Our reference: R/2021/10/A

Your reference: SSD 32927319

Subject: Advice on EIS - Powerhouse Ultimo Renewal - Stage 1 - SSD 32927319

Figure 11.22 Turbine Hall Grading of Significance (Roof) (Source: John Wardle Architects plan with Curio Projects overlay)

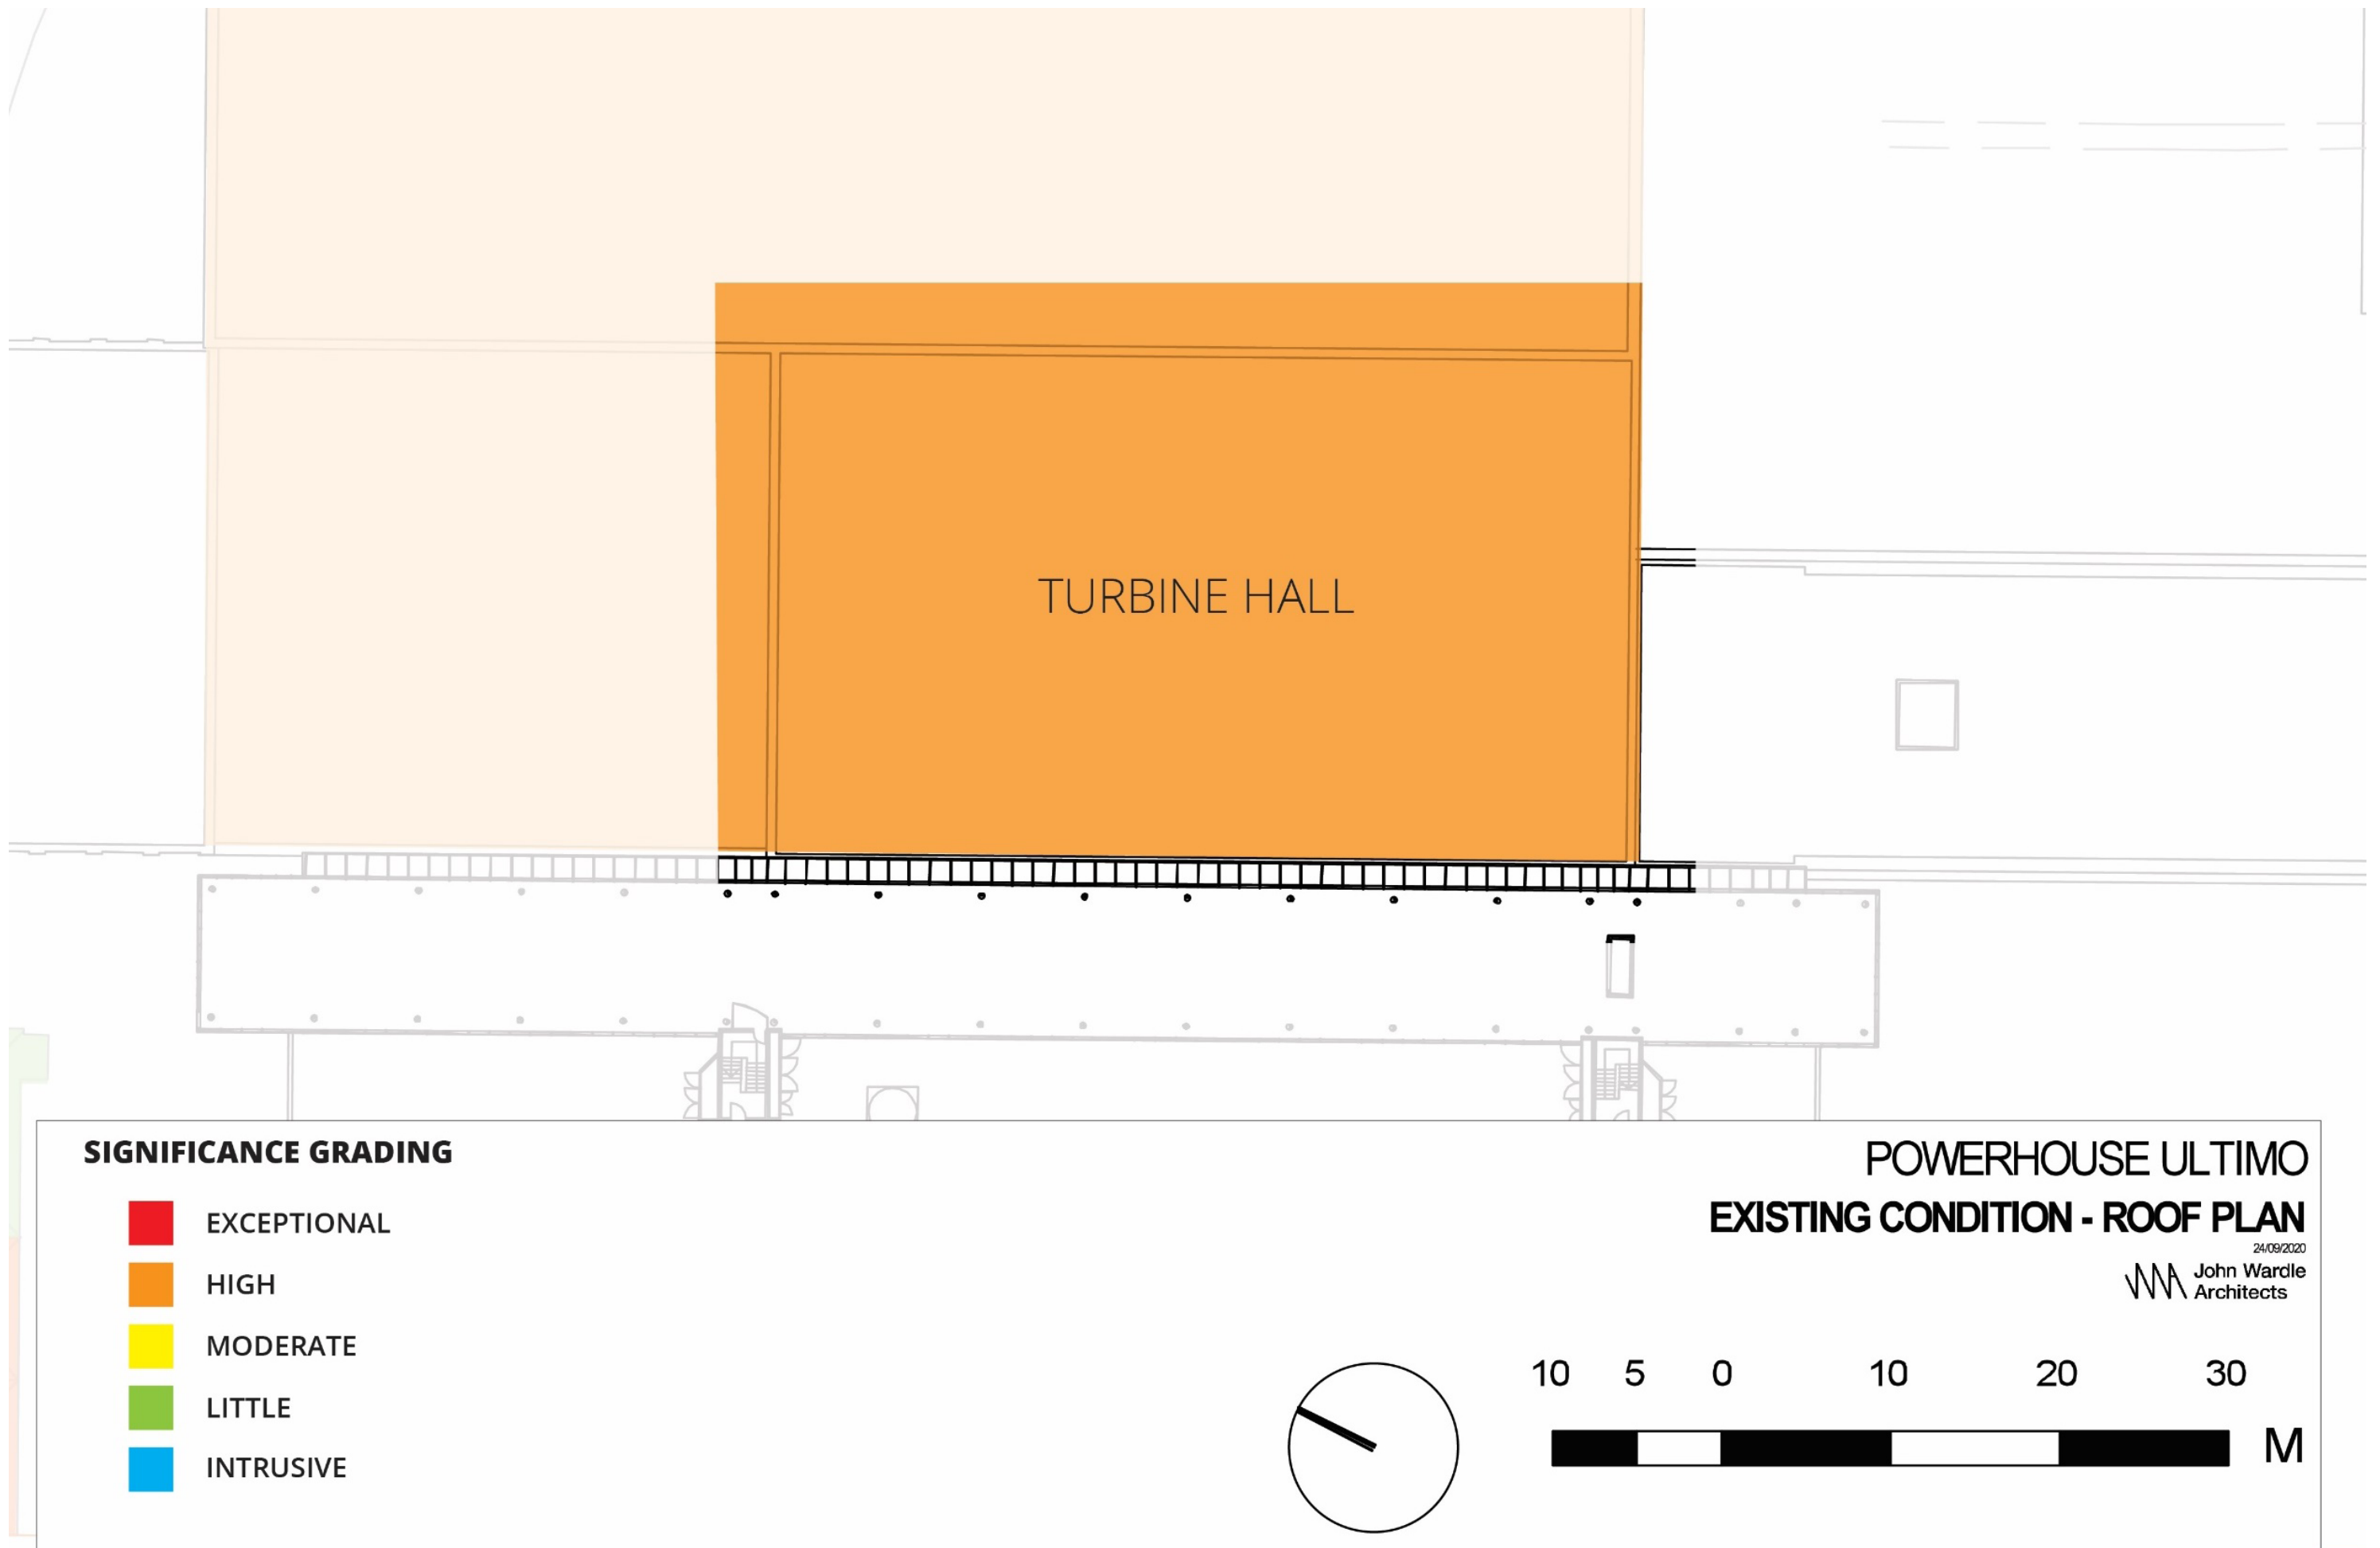
- Section 4.4 Heritage curtilage and Section 4.5 do not comprise a sufficient curtilage analysis.
- Sections 4.6 Gradings of significance – The plans representing the gradings in Part C should be consolidated into Part 4.6, as one single detailed plan of the site. The plans in Part C are too large to be legible. At present the plans in part C are too fragmented to be readily located. The grading of significance should evaluate the buildings in 3 dimensions, represented in sections and elevations of the buildings to pick up elevation detail, roof forms, internal structural elements, fabric and components such as gantries. The roof plans should identify all the distinctive roof forms such as lanterns and chimneys.

1 NORTH EAST ELEVATION  
Scale 1 : 500

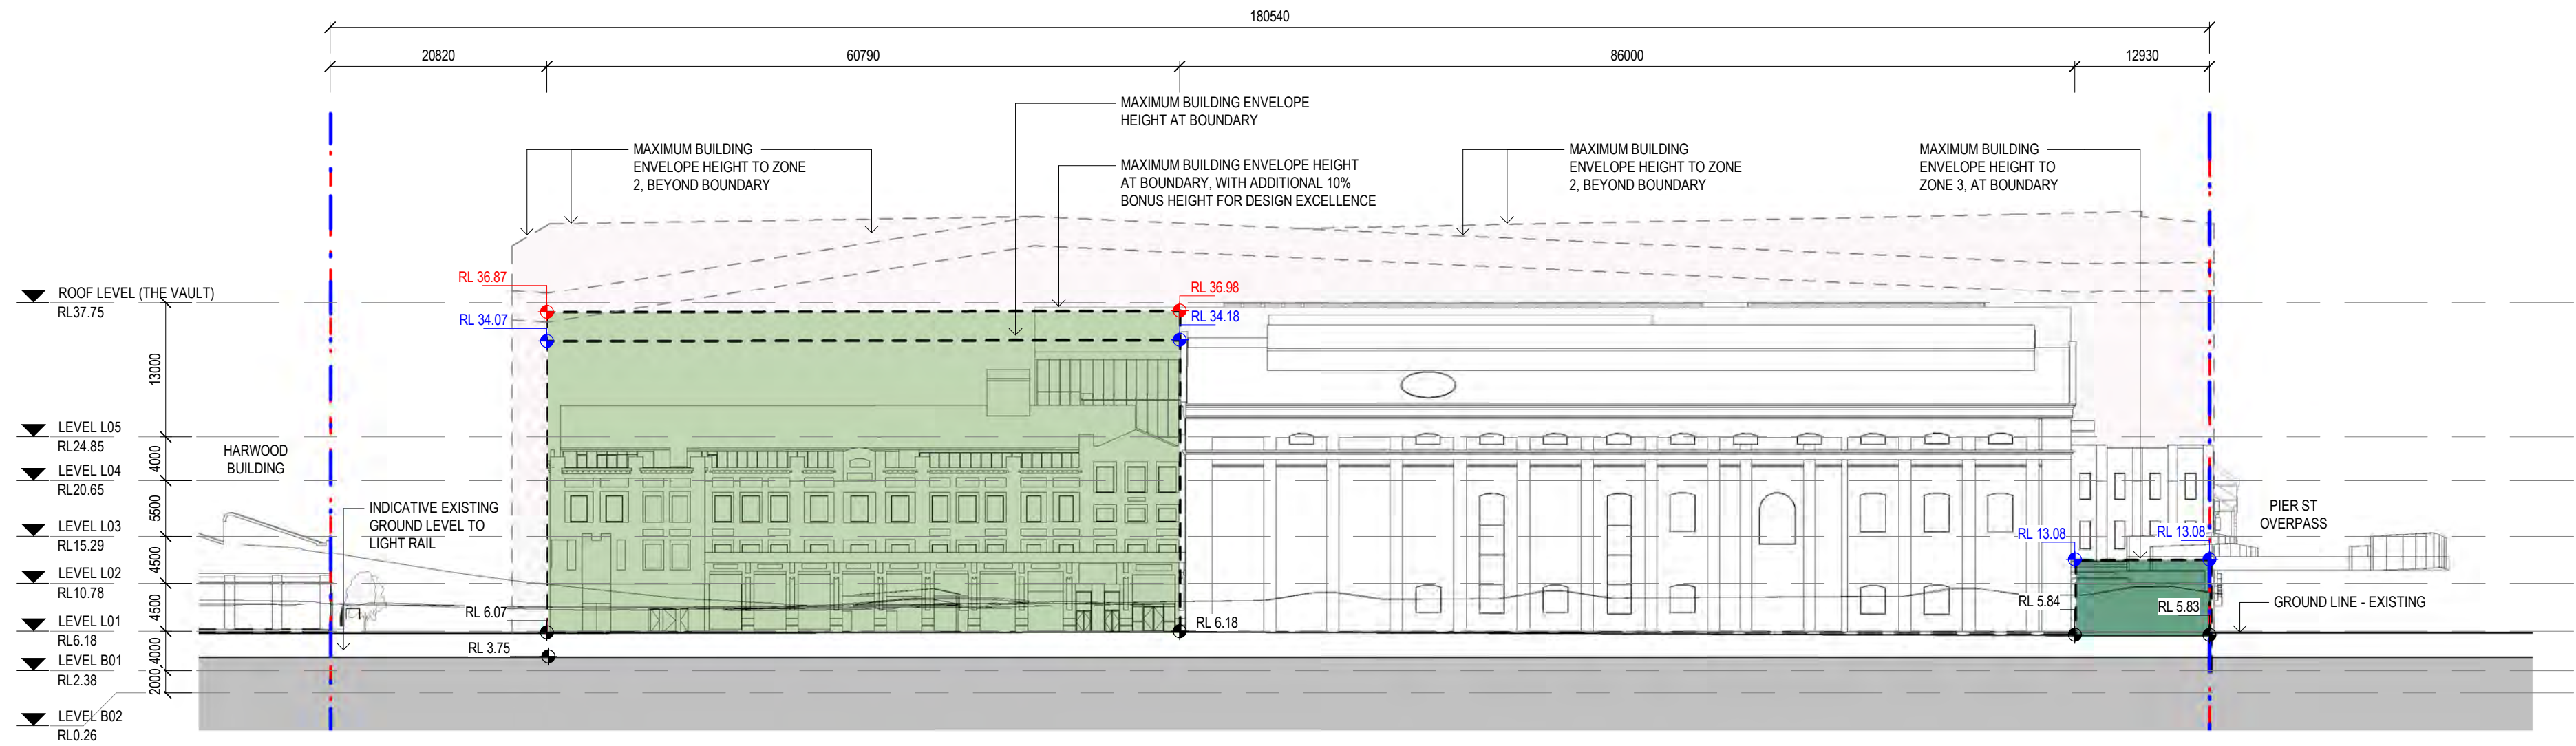
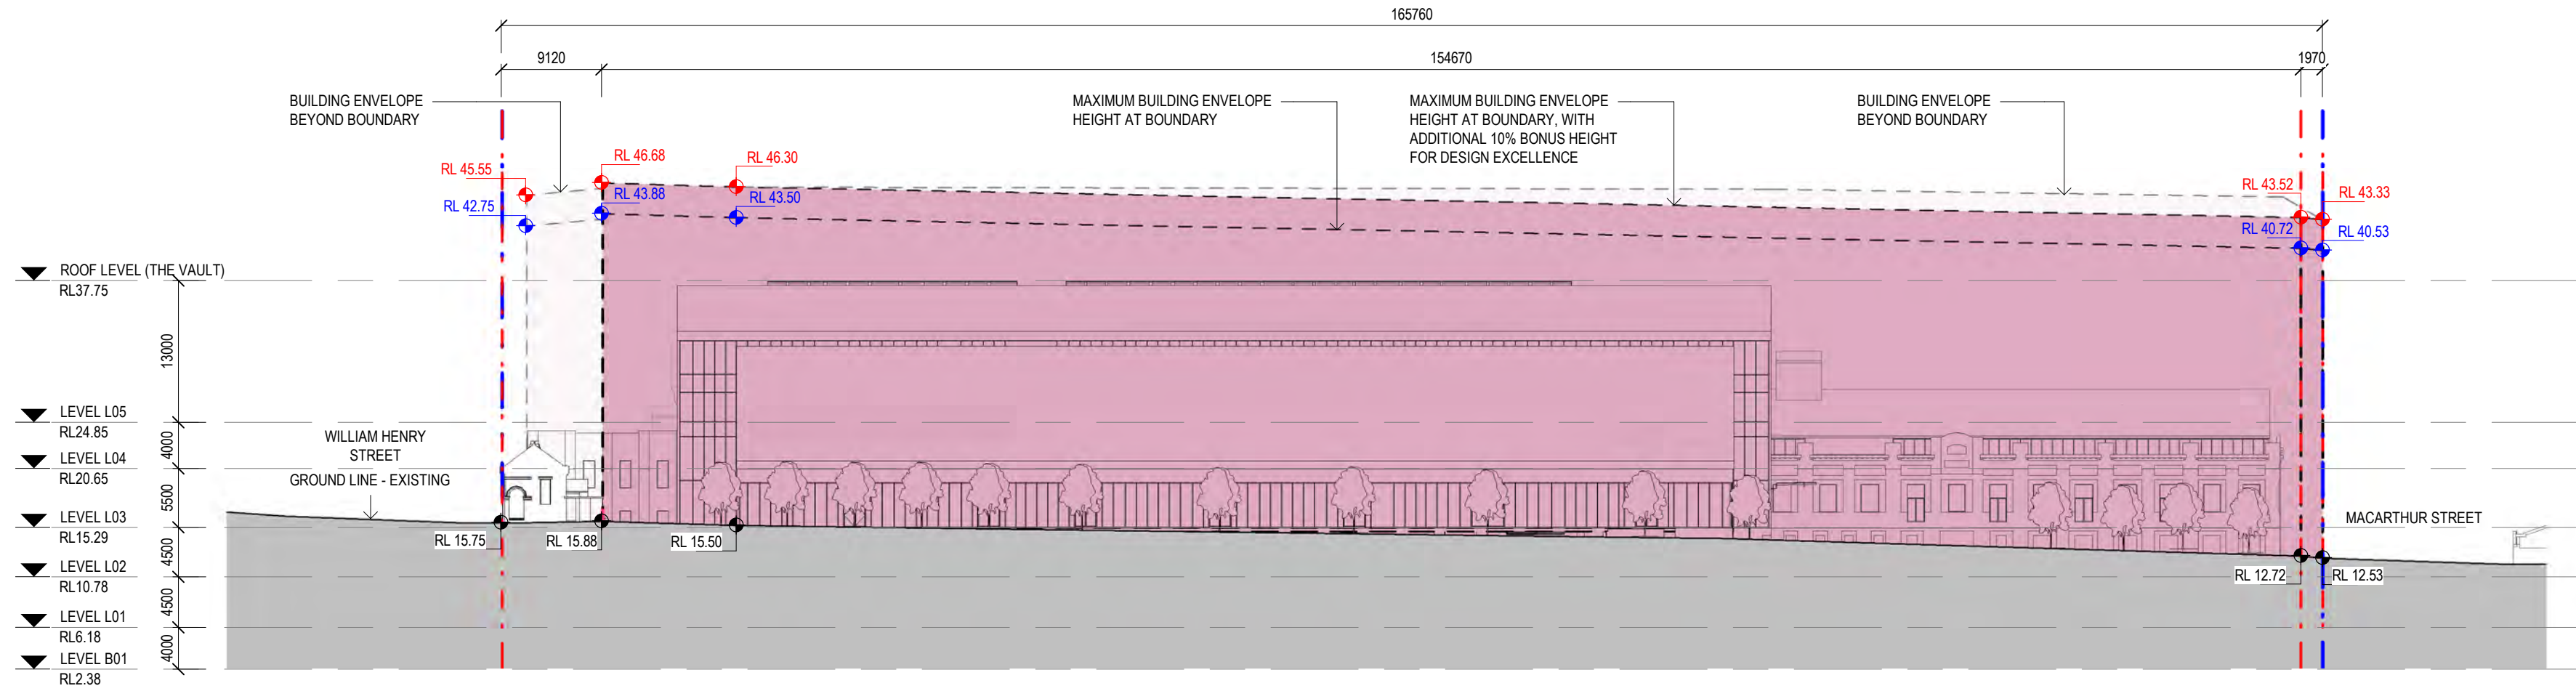
The submitted building envelope and massing drawings provides a series of coloured planning envelopes across the site. While envelopes surrounding and above items of no heritage significance are understood, clarification is sought as to why planning envelopes are identified above the existing heritage listed items. Whilst the envelopes above the heritage items only extend to or just above the existing heights of the buildings, clarity is needed as to the purpose of the inclusion of a planning envelope above the original roof form of the heritage listed buildings. Is development permitted or anticipated above the heritage listed buildings, or this is a tool to differentiate those envelopes where height can or cannot be explored. The City assumes that the heritage items being of local and state significance shall be retained in their current form and any development above their roof is to be avoided. Separate to this observation, the City has previously discussed with the Powerhouse forthcoming amendments to the LEP to allow the Powerhouse site(s) to be potentially eligible for an award of heritage floor space for its conserved heritage listed buildings. To be eligible for an award of HFS in the future, the heritage listed buildings should not be subject to works that would increase the external envelope and floor space of the building other than a minor increase to facilitate the adaptive re-use of the heritage building.

As mentioned at the beginning of this section, additional height above the heritage buildings (and the whole of the heritage listed lot) is assumed to be not permitted or encouraged. It is considered contrary to objectives (a) and (b) of Clause 4.3 of the Sydney Local Environmental Plan 2012. The proposed height would not represent design excellence in relation to the heritage items, therefore no additional bonus height should be granted for the 'Heritage Core'. Further, the bonus of 10% for design excellence is not appropriate in this location due to the inherent potential heritage impacts of building additional volume above the heritage items. No additional height should be permitted above the heritage listed buildings, for the following reasons:

- Additional built form above the heritage items would obscure the distinctive profiles and forms of heritage listed buildings of exceptional significance. The legibility of the historic built forms and the appreciation of the buildings in significant views would be diminished. The distinctive and significant roofscape includes pitched roof forms, roof lanterns, chimneys and castellated parapets. The array of the forms of the heritage buildings has been described by Lionel Glendenning, the Powerhouse Museum architect, as being 'like a town', or a townscape.

The conflict between the 10% additional height over the northeast courtyard and the proposed Landscape Plan in Appendix showing it remaining as open space is confusing. The additional height over the heritage listed Lot 1, DP 631345, which includes the northeast courtyard and associated rail tracks could negate the heritage significance of this space.

The proposed envelope above the former Pump House could diminish views of the Pump House, and the Boiler House and its roofscape from Pier Street and Darling Harbour. There is no visual curtilage analysis to justify this envelope.
